CITY OF ALBUQUERQUE

**RE: Calvary Church – Gym Building
Grading & Drainage Plan/Report
Engineer's Stamp Date 5-31-2016 (File: J22D027A)**

Based upon the information provided in your submittal received 6-1-2016, the above referenced Grading and Drainage Plan and Report is approved for Building Permit with the following condition:

PROJECT NO: 162004
DESIGNED BY: RJF
DRAWN BY: RJF
CHECKED BY: RJF
DATE: MAY 2016
SHEET TITLE
**DRAINAGE
GRADING
PLAN**
SHEET NO:
C4

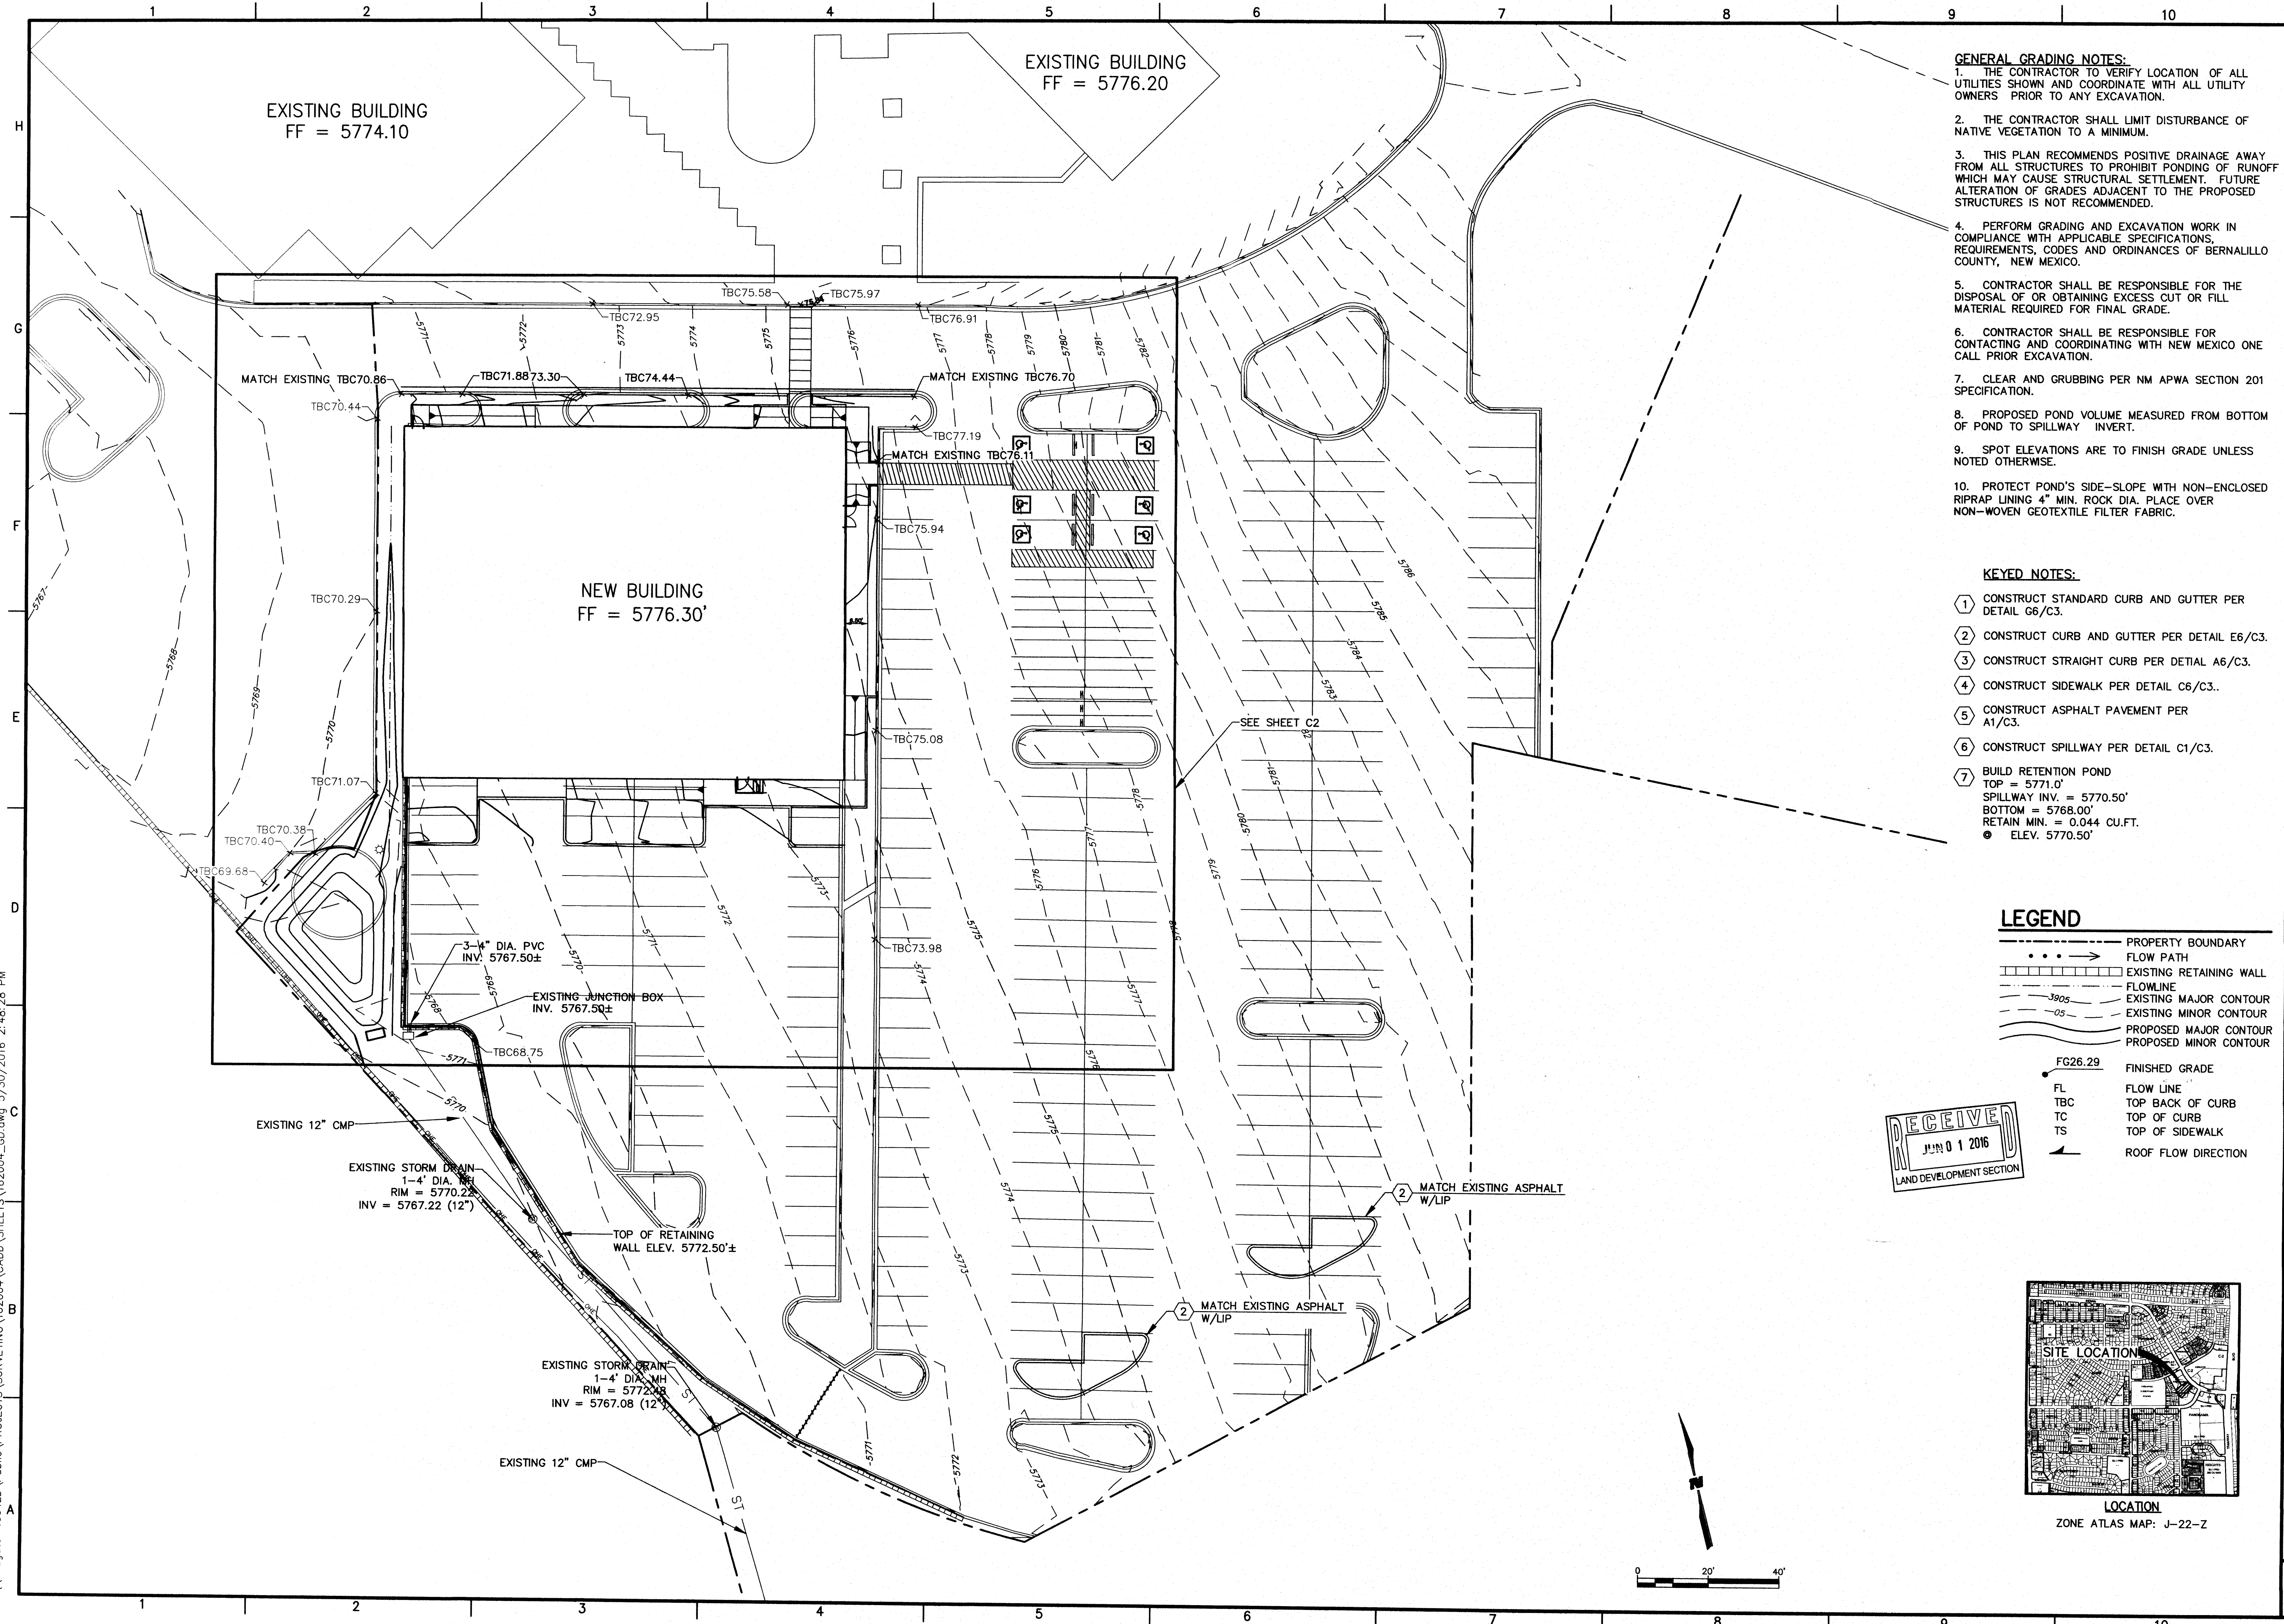
- The roof drains will not be allowed to discharge onto the sidewalk surface, flows need to be routed under the sidewalk with a culvert or piping. These improvements will need to be shown on the certification.
